# HERBATA DATA CENTRE, NAAS - RESPONSE TO REQUEST FOR FURTHER INFORMATION ("RESPONSE TO RFI") FROM KILDARE COUNTY COUNCIL

## ADDENDUM TO CHAPTER 5 BIODIVERSITY

NI2615  
01  
June 2025

DWG NO: 22217-RKD-ZZ-ZZ-DR-A-1400

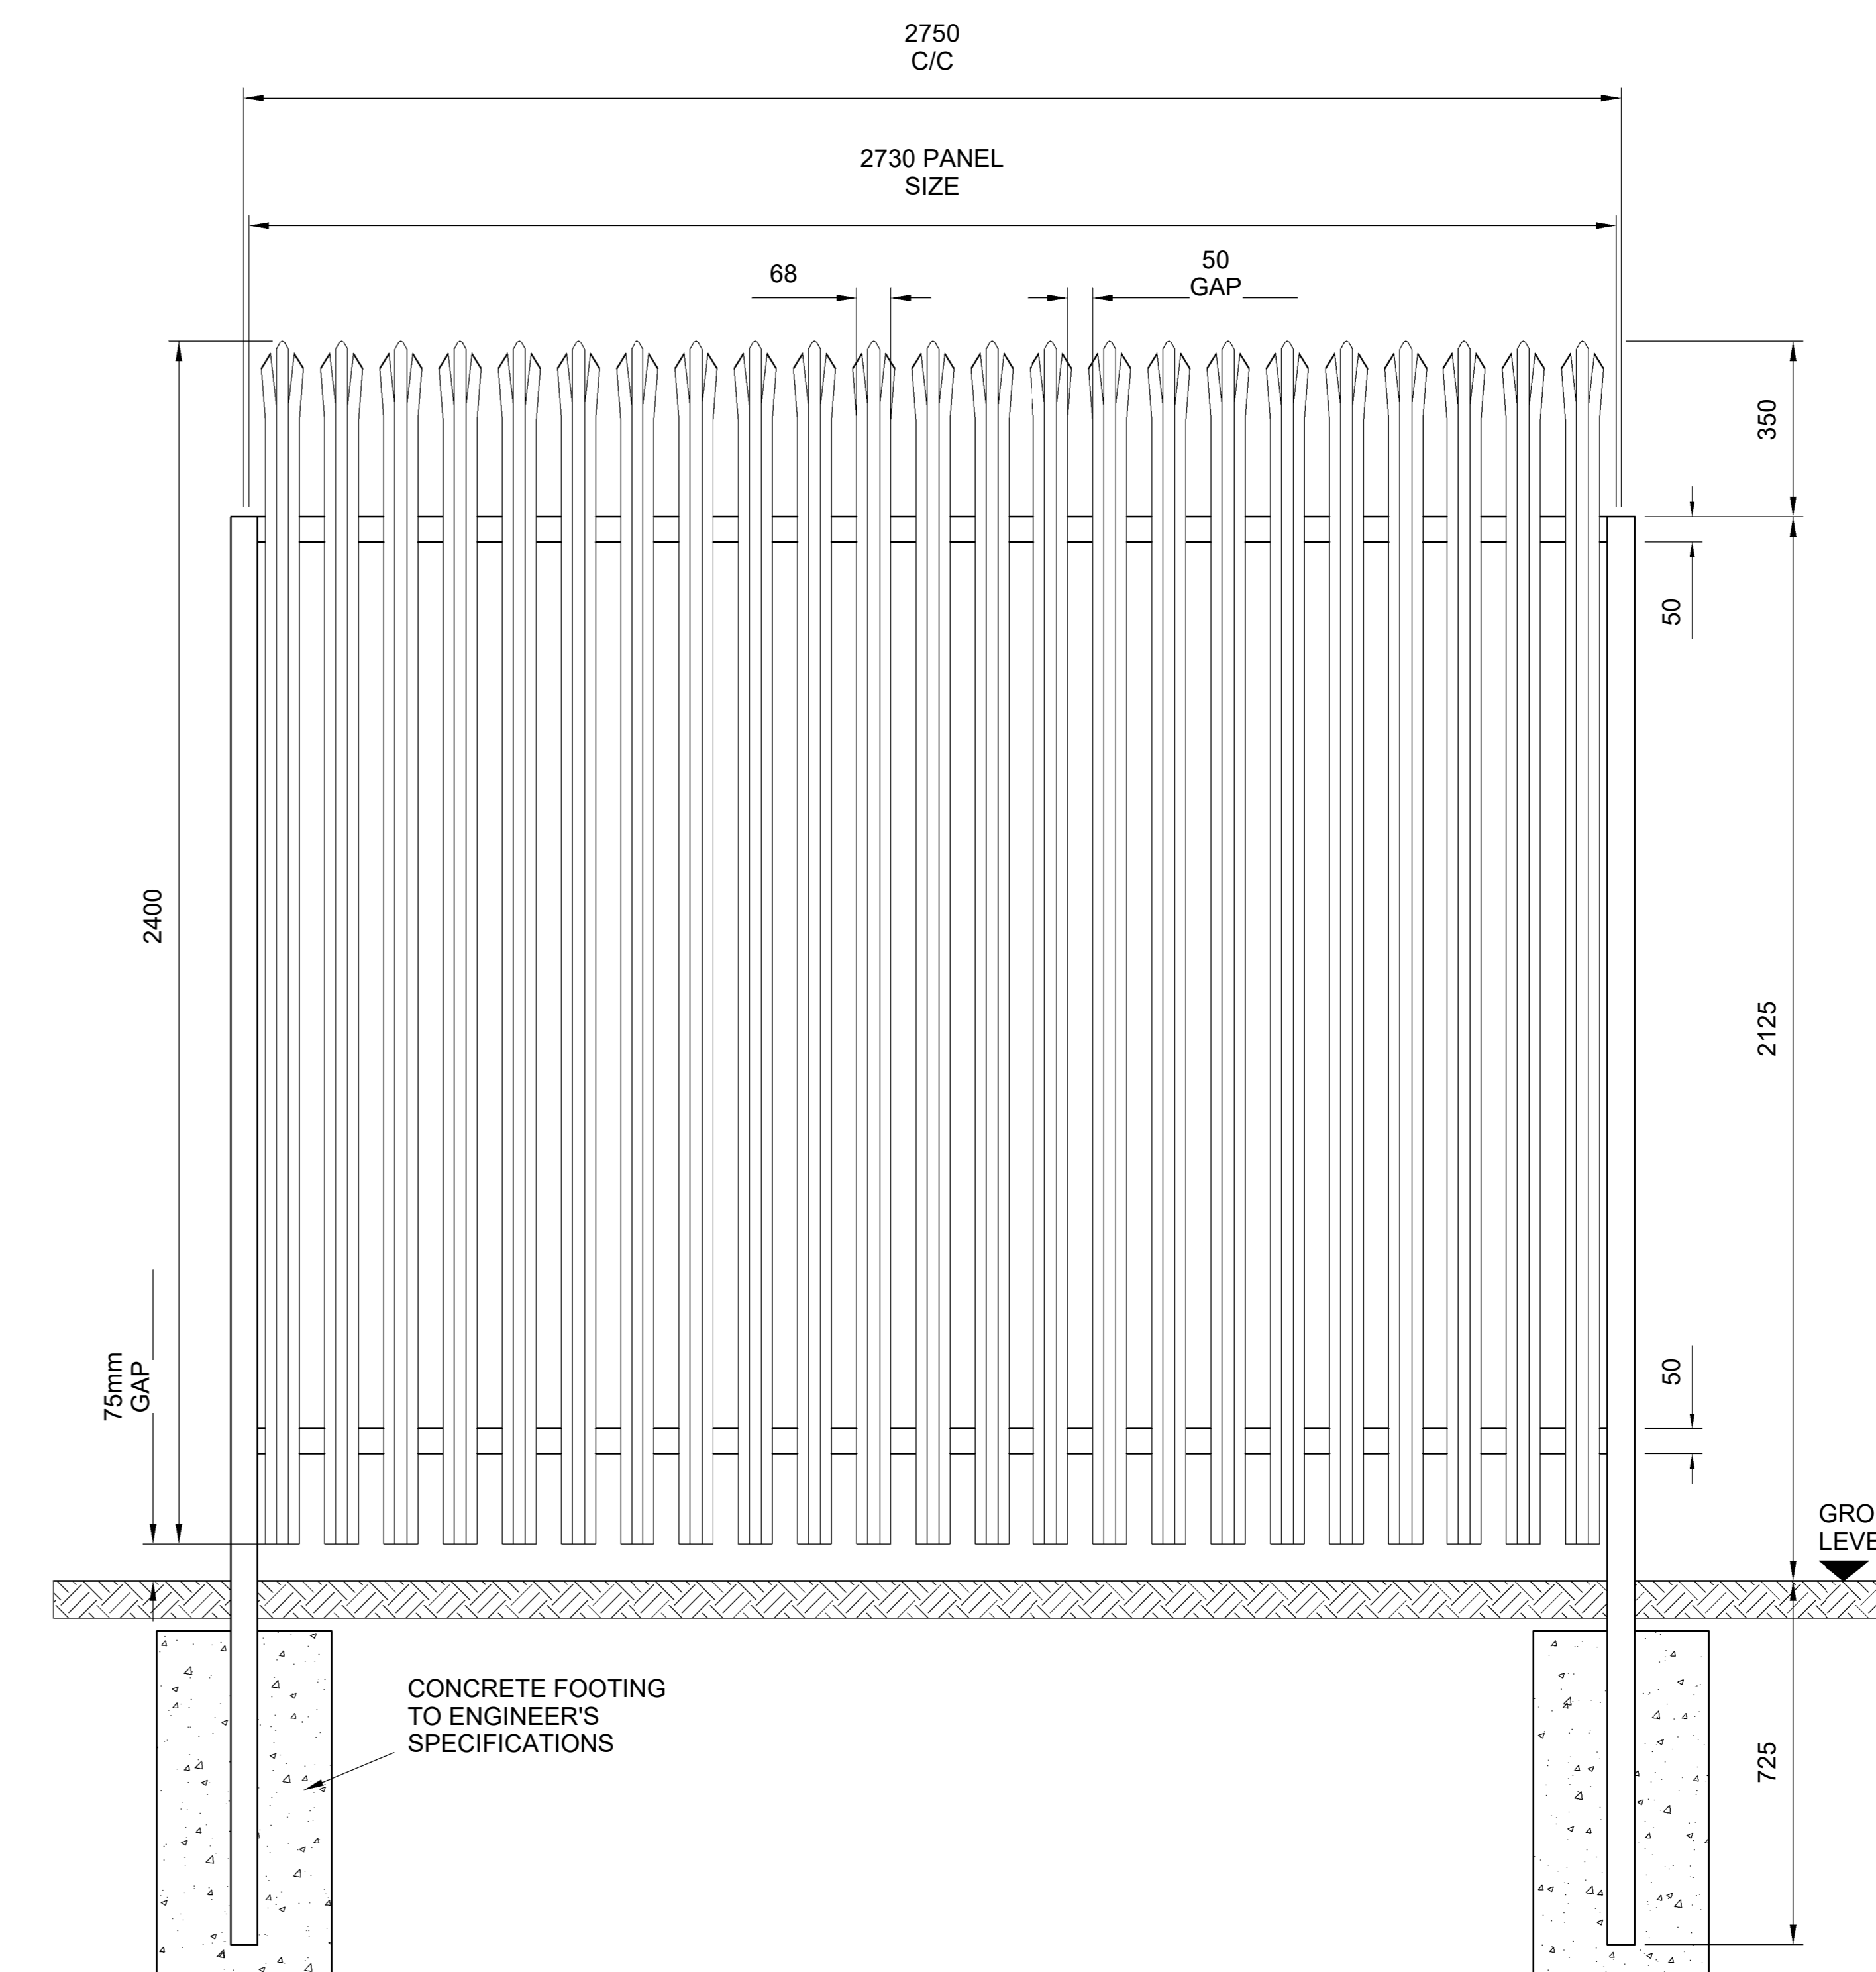
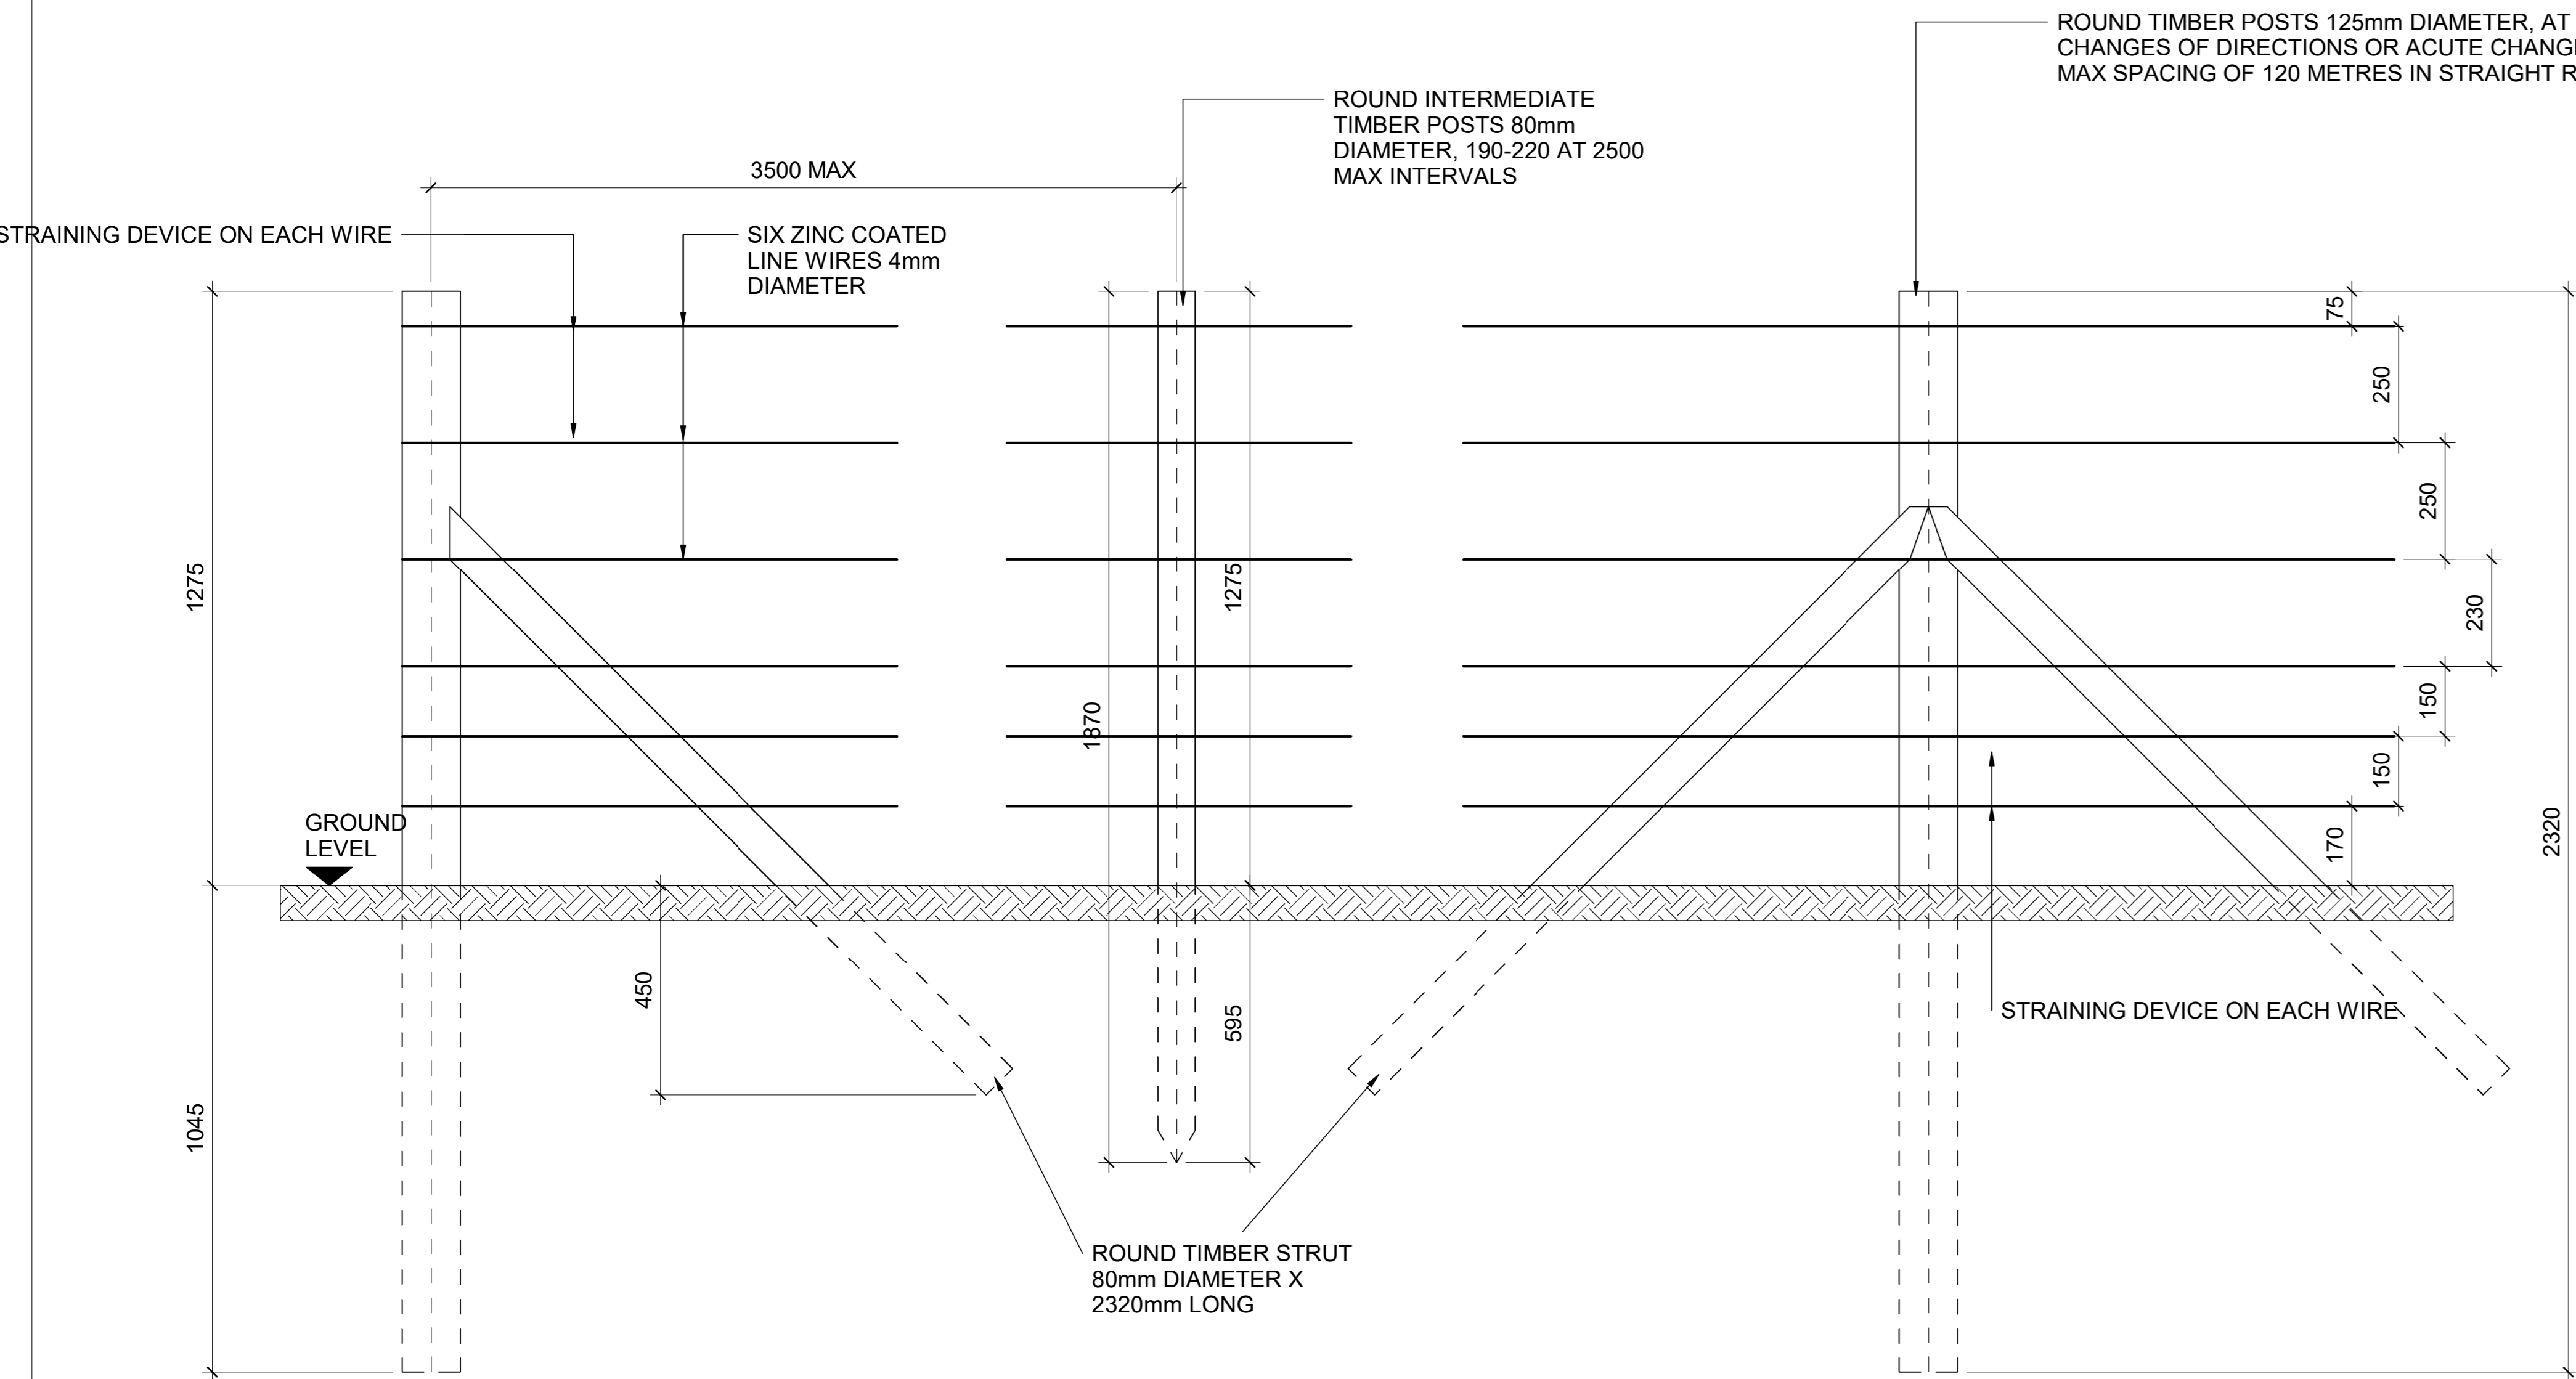
*6. The proliferation of palisade fencing throughout the site is noted. Notwithstanding the security rationale for the proposed fencing, the applicant is advised, having regard to the scale of the proposal, that there is insufficient consideration given to the passage of wildlife through the site and this should be facilitated by appropriate fencing. The Applicant is requested to revise the proposed fencing arrangement on site to allow for wildlife access and passage through the site. An addendum to the Ecological Impact Statement shall accompany the revised fencing proposals.*

In consideration of the request for inclusion of a fencing arrangement *to allow for wildlife access and passage through the site*, an amendment has been made to the proposed Landscape Masterplan to include mammal passes in fences throughout the full extent of the site. The number, location and dimensions of the mammal passes was established following engagement between the project ecology and landscape team. The inclusion of the mammal passes has not required changes to the submitted landscape planting proposals.

Mammal passes are proposed at locations throughout the site including all *perimeter* fences and *internal* fences within the site (for example around each Data Centre building). The gap at the foot of the proposed fencing, of 500mm (width) x 200mm is sufficient for all potential mammal species and will ensure access and passage throughout the site, in line with the request from Kildare County Council. There are no proposed amendments to the overall height, materials or layout of the proposed fencing.

Figure 5.1 below (extract of drawing number BSM-ZZ-ZZ-DR-L-0311 Landscape Boundary Treatments Plan) illustrates the location of the mammal passes; Figure 5.2 below (extract of drawing number 22217-RKD-ZZ-ZZ-DR-A-1400 Proposed Boundary and Fence Details) illustrates the detailed dimensions of the fencing.
